Response to Planning Application

From: Arun District Council Greenspace

Application ref: Y/57/21/PL

Location: Sunnymead North End Road Yapton BN18 0DL

DATE	September 2020	DRAWN	MH
DRAWING NUMBER	20148-03	REVISION	B

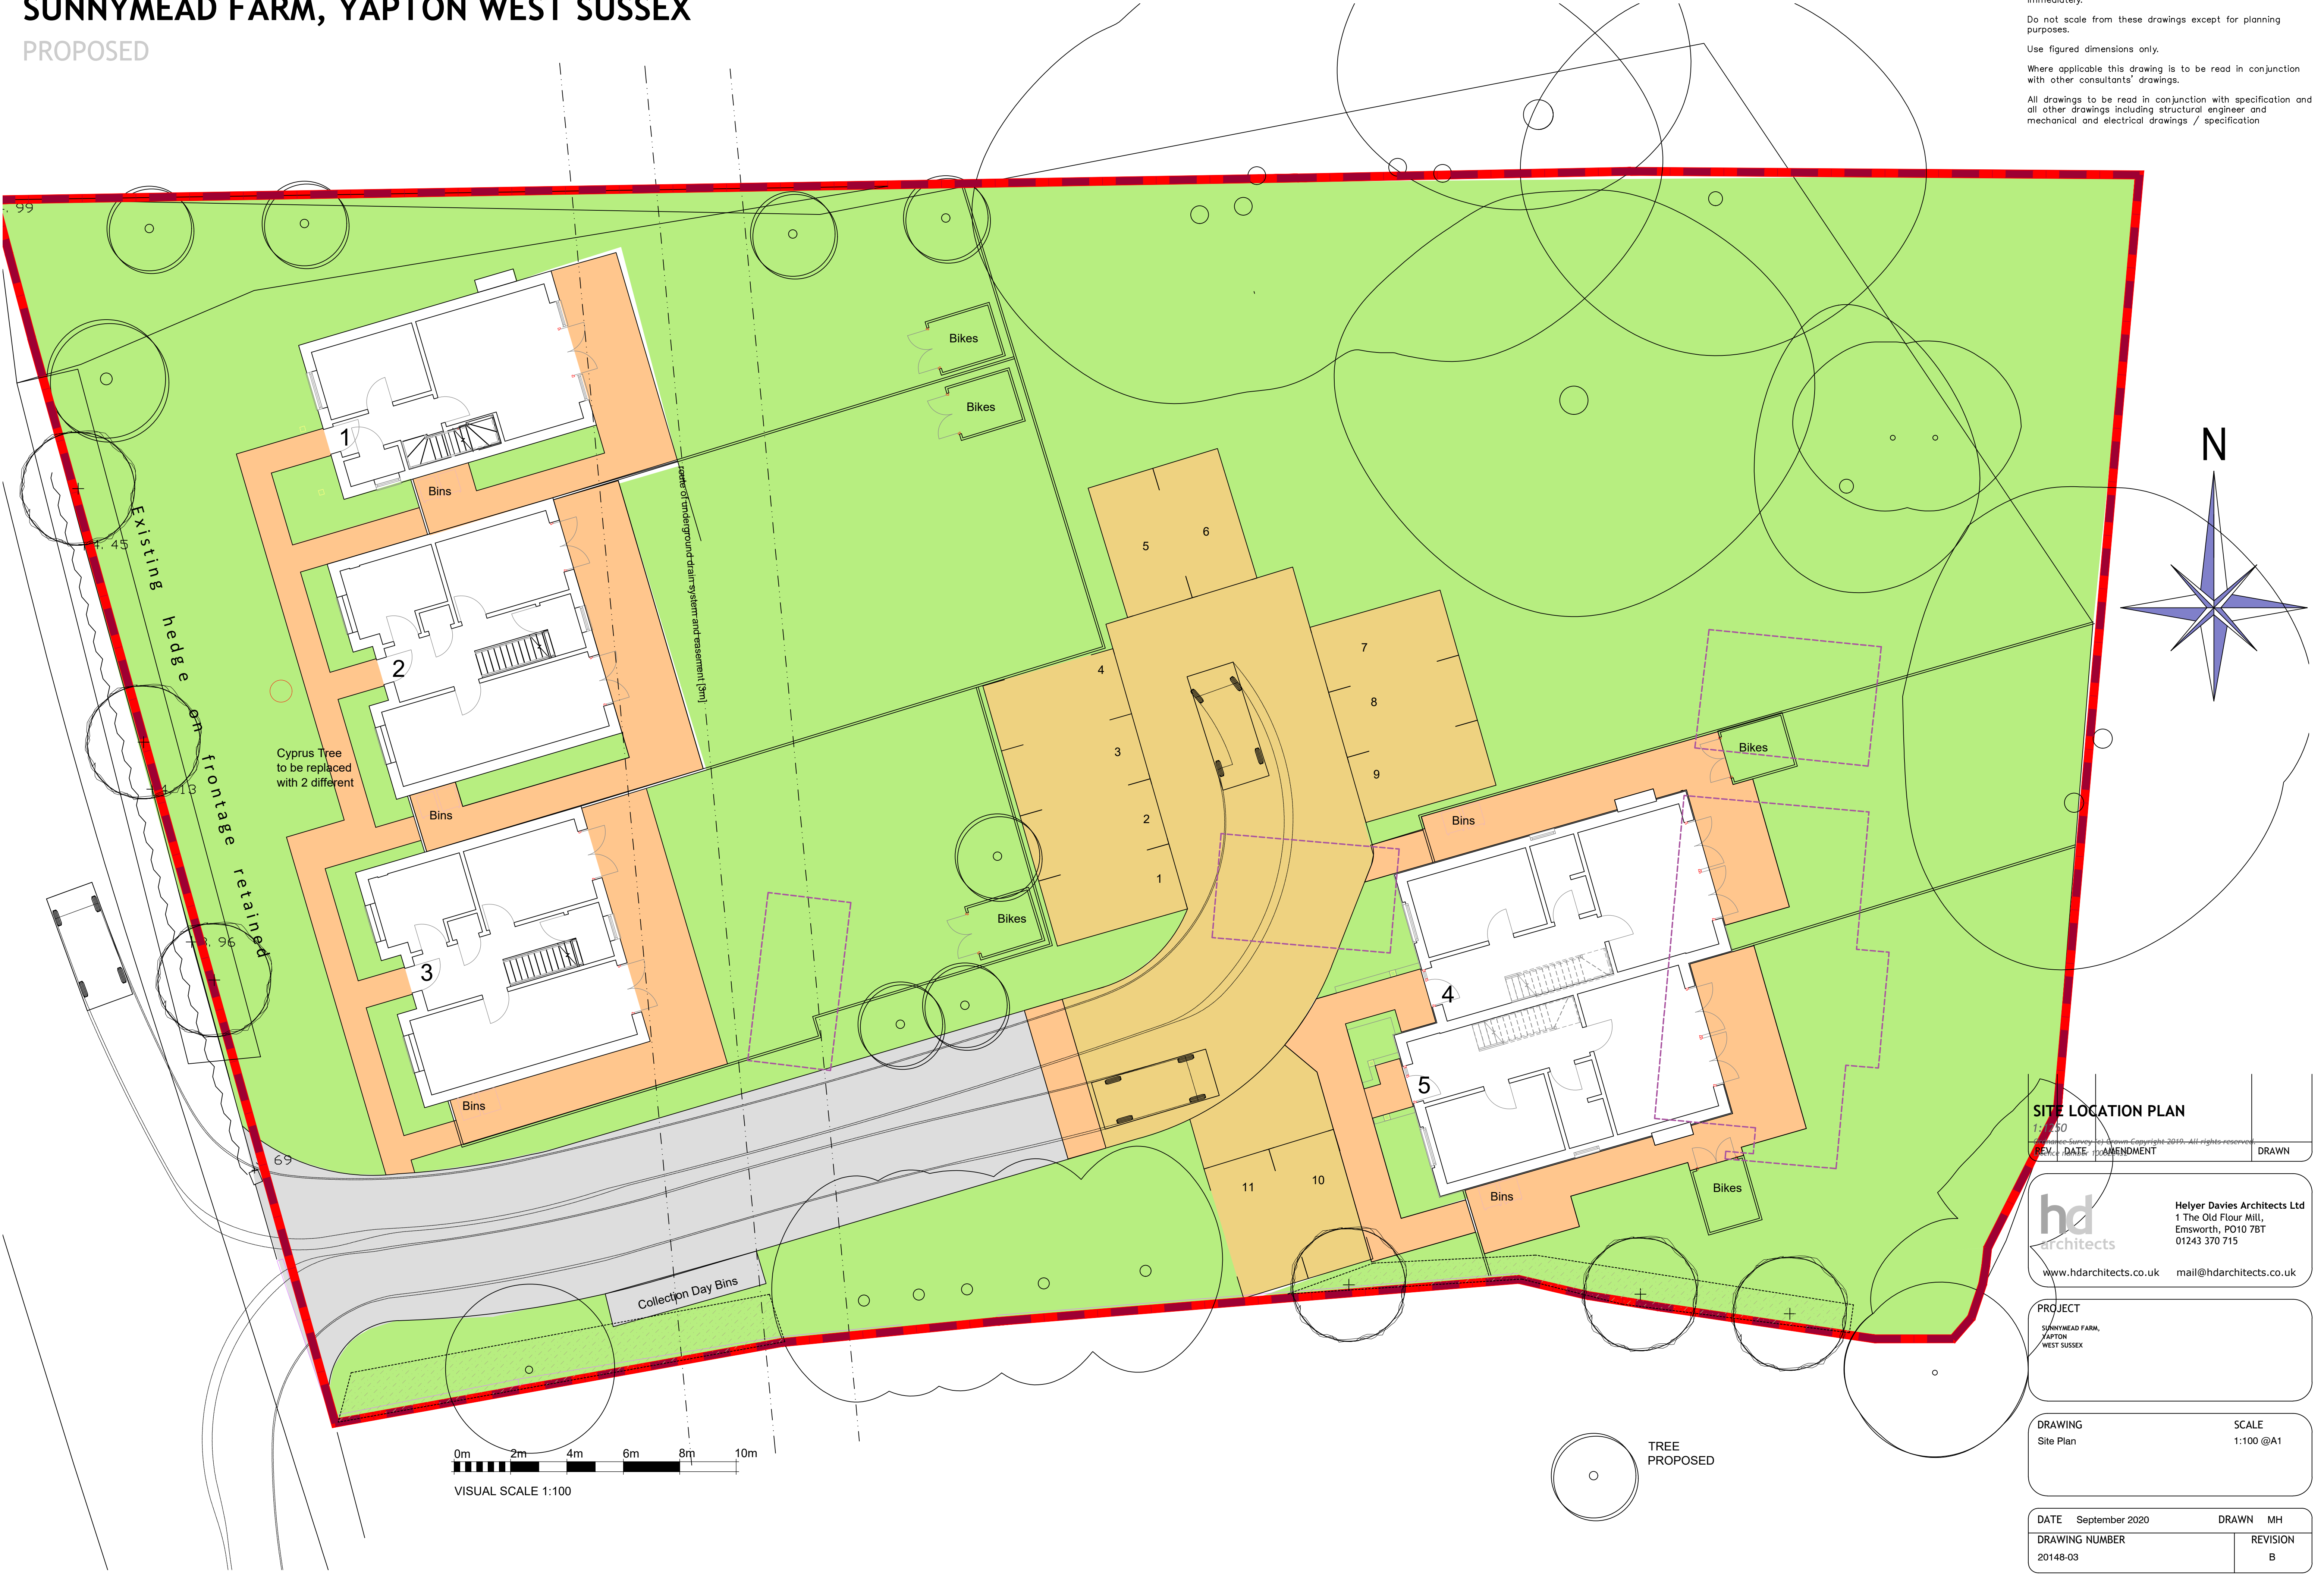
The indicative site layouts would appear to have conflict with existing trees and hedges and detail re tree retention and protection plans appears to have been submitted. Any proposed tree removals must be in consultation with the LPA Tree Officer.

Landscape provision to the new dwellings and improvement with native species infill plus further boundary screening as required. These details would require expanding in the form of a detailed planting plan and specification detailing species choice, actual plant quantities, planting densities and size at time of planting. Detail should also be provided to show these in relation to the existing trees and boundary planting.
